Odour Assessment Review
Land at Ford Airfield, Ford,
West Sussex
November 2021

Project no.	Project
8693C	Odour Assessment Review: Land at Ford Airfield, Ford, West Sussex

Client	
Arun District Council (ADC)

Report No.	Version	Prepared by	Checked by	Authorised by	Date of issue
11050	V0	H. Parfitt	P. Beckett	P. Beckett	19/11/2021

SCALE

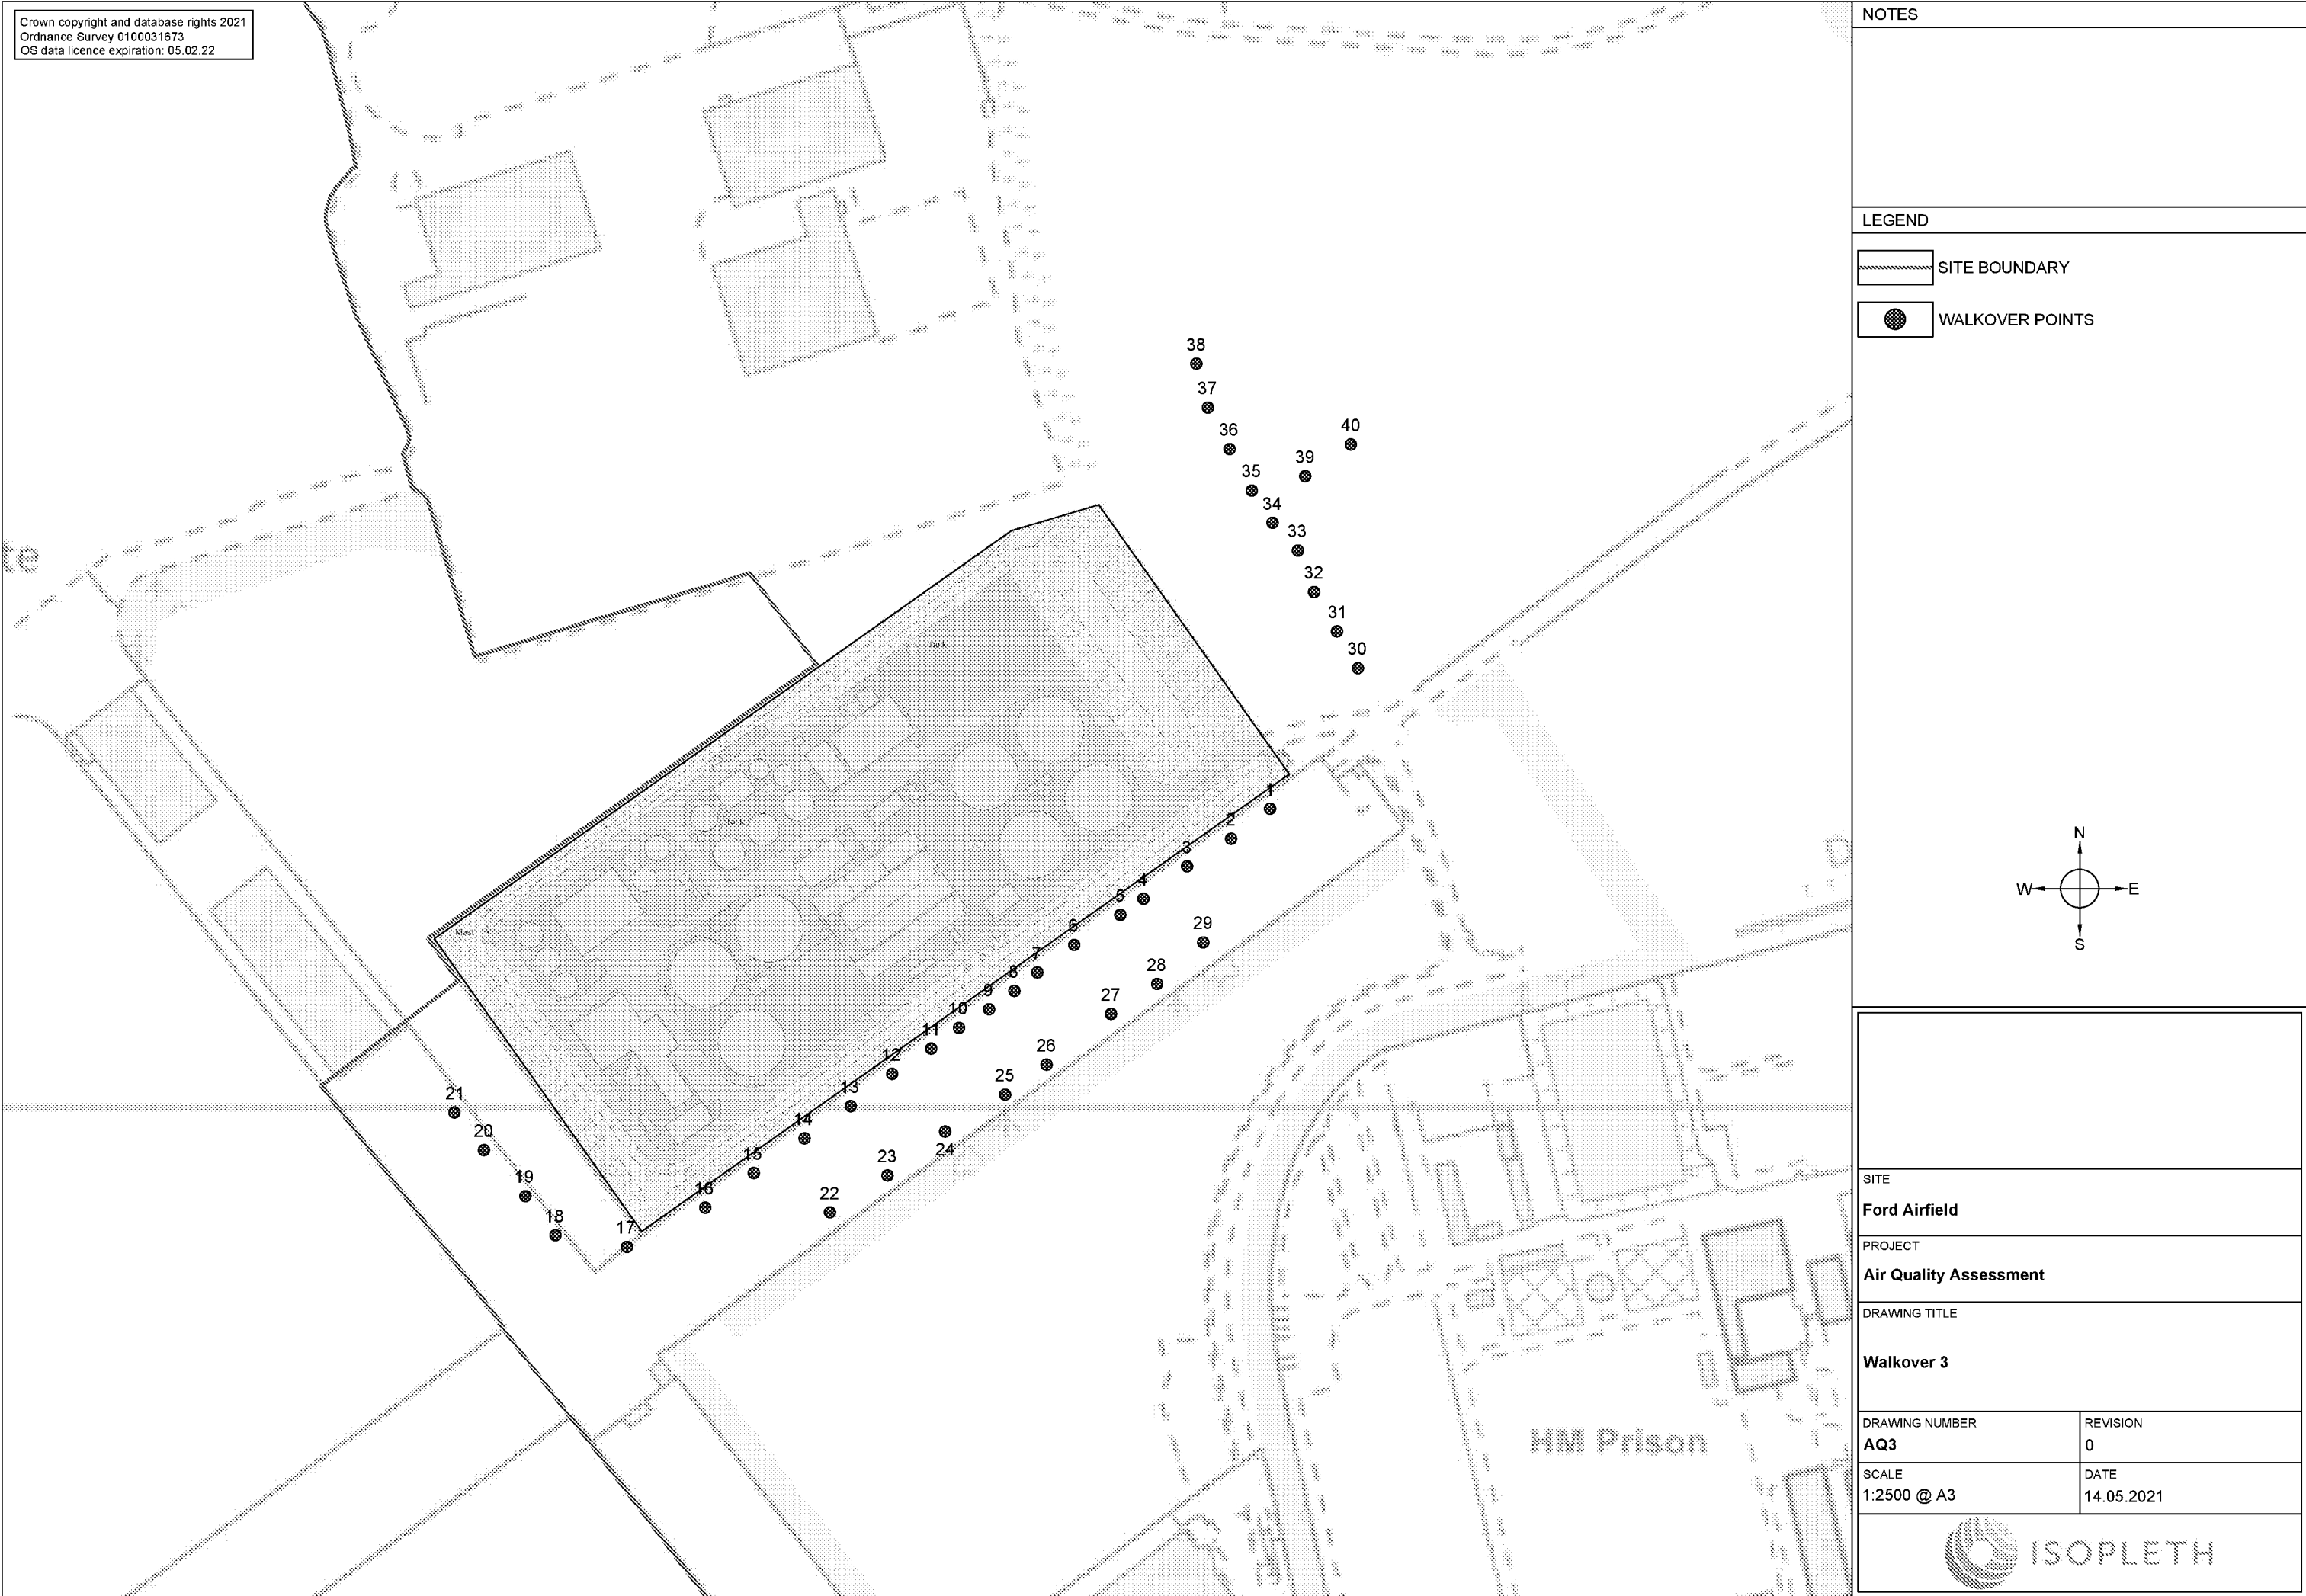
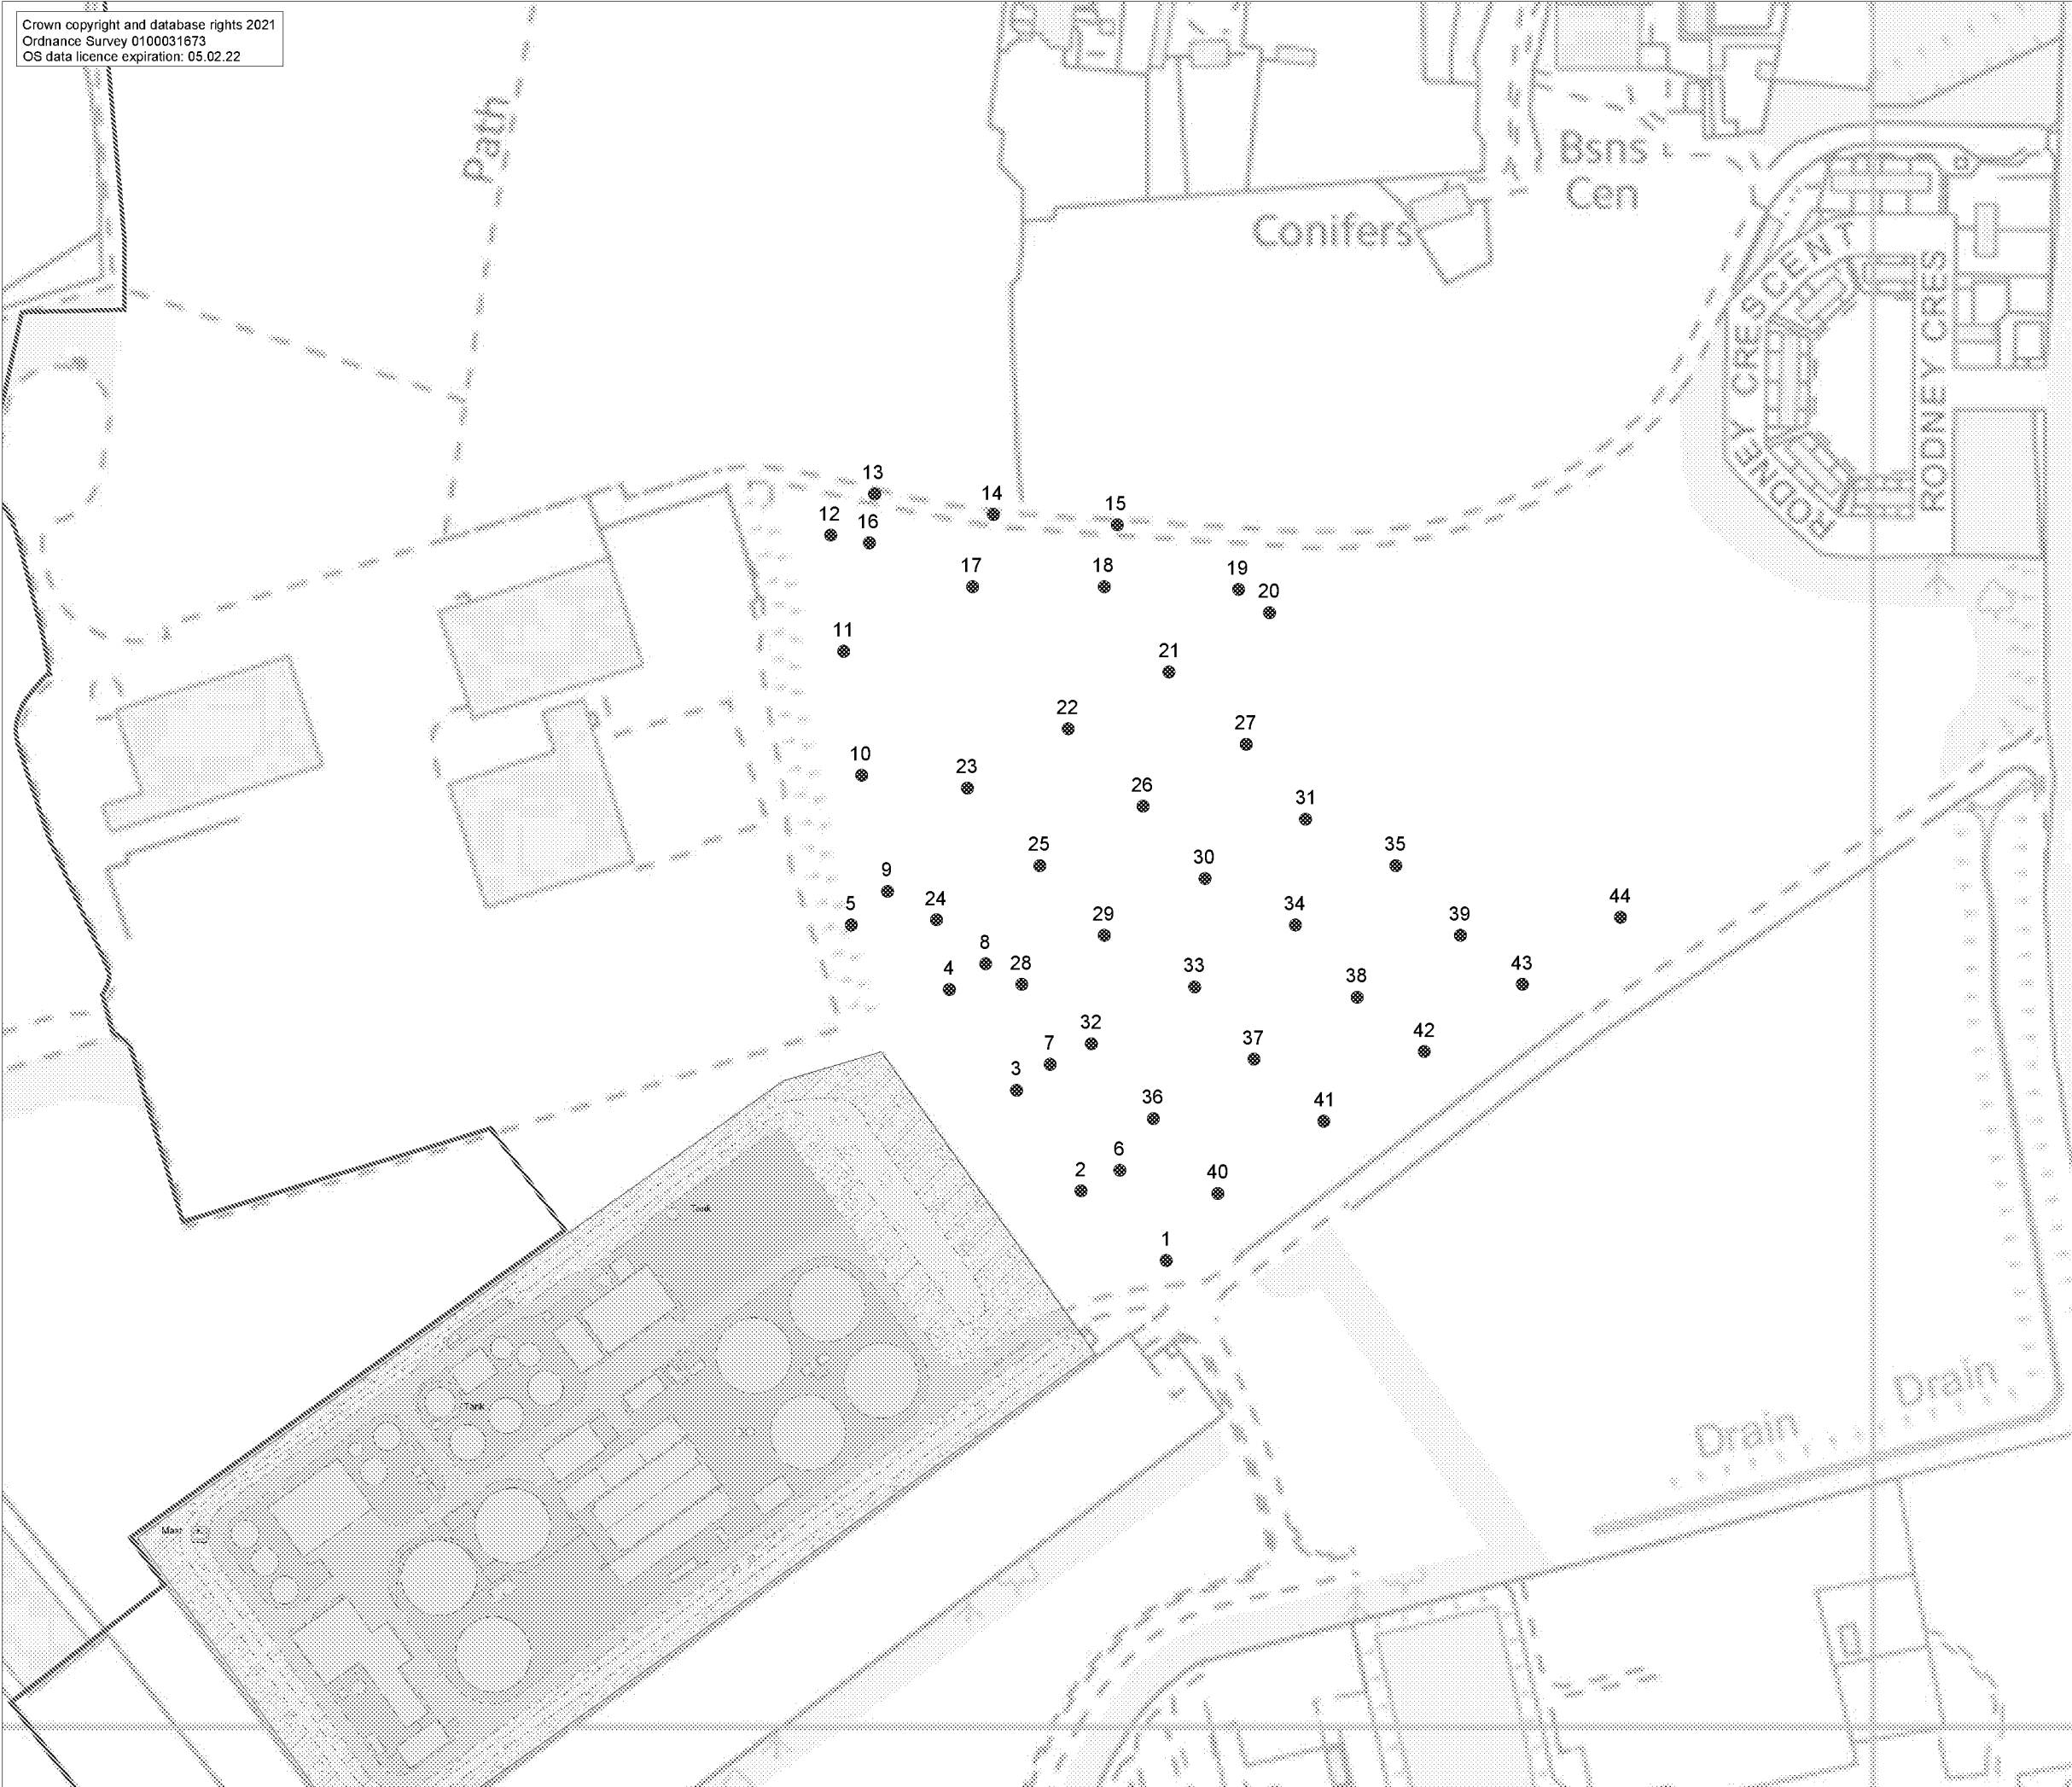
- 2.30 During walkover/sniff test 1, strong odours could be detected transiently but regularly up to 120m from the WwTW boundary, and at least 300m from the most odorous part of the WwTW, i.e., the main works odour control unit. The three locations where strong odours could be detected were not the three closest, as is suggested in the report, suggesting that a plume from the OCU might be grounding there.

- 2.31 Nevertheless, there is consistency in the results of the sniff tests (i.e., that the area within 100m of the WwTW to the NW is regularly exposed to strong odours that could be *"regarded as 'substantial adverse' for a residential receptor and 'moderate adverse' at a commercial receptor"*. This area is at least 300m from the most odorous part of the WwTW, i.e., the main works OCU.

- 2.32 During sniff test 3, strong odours could regularly be detected along the WwTW southern boundary (locations 5 to 14); however, strong odours quickly dissipated when sampling at locations 22-29, which were circa 70m to the south. The sniff test did not sample at greater distances to the south. It is, therefore, unknown whether odours could be detected at 300m distance from the main OCU, as they could be to the north-east of the WwTW. This is a possibility given the height and design of the OCUs, which would allow odorous air to ground at greater distances from the facility.

- 2.40 For example, the sniff tests find that moderate & substantial adverse impacts (assuming residential uses were present) could be consistently detected to the north-west of the WwTW up to 100m from the site boundary, and over 300m from the most odorous part of the WwTW. However, the modelling suggests impacts would be, at worst, 'slight adverse' at this location. This suggests that impacts associated with normal operations of the WwTW could be under-predicted to the north-west of the facility and that the model is not performing in line with the prevailing meteorological conditions and with the ground based observations.
